Ref: 11 Brearley Close / 56046/APP/2023/2087

This is the revised planning application and according to your email dated 07/09/2023,

SITE ADDRESS			11 BREARLEY CLOSE UXBRIDGE UB8 1JJ		
DRAWING TITLE:			EXISTING AND PROPOSED FLOOR PLAN		
SCALE:		1:100 @ A3		DATE	29-10-2023
DRAWING NO:		23/BC11/0015		REV	DATE

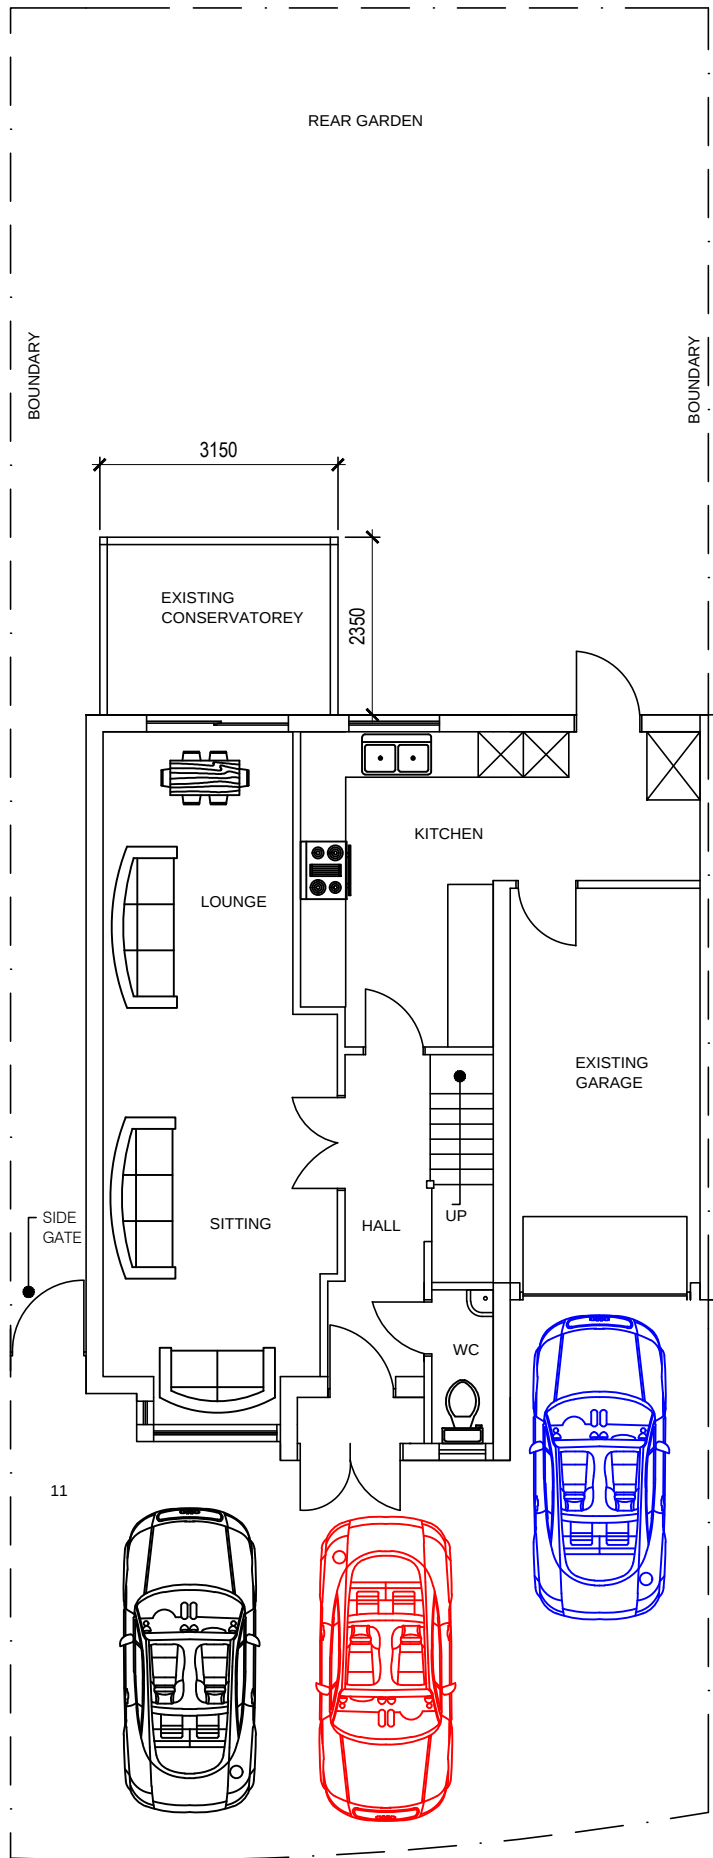
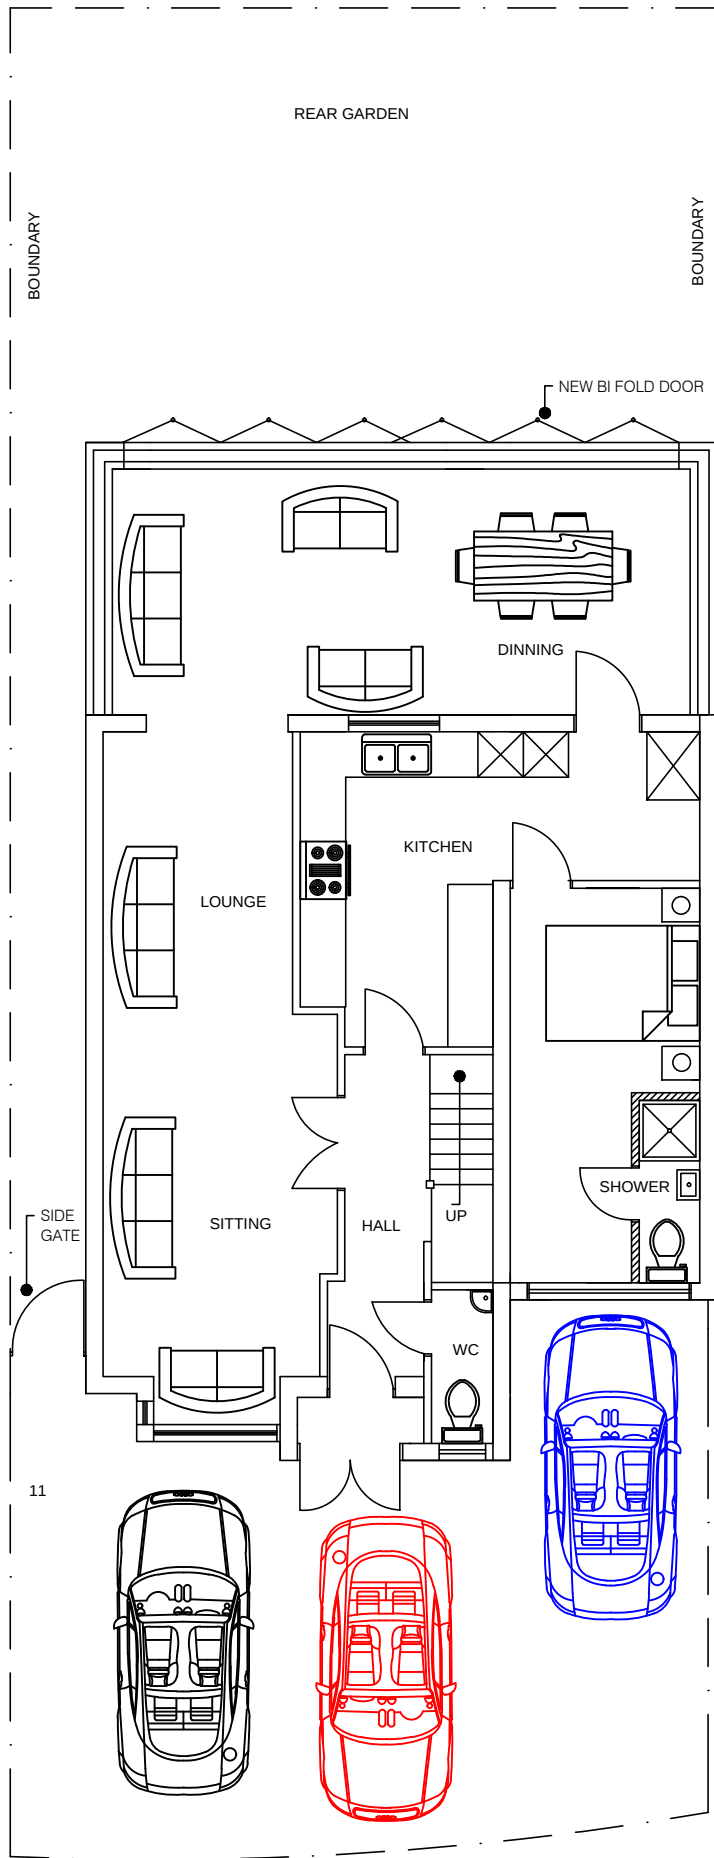
now reduced the depth of the proposed rear extension to 3.6M
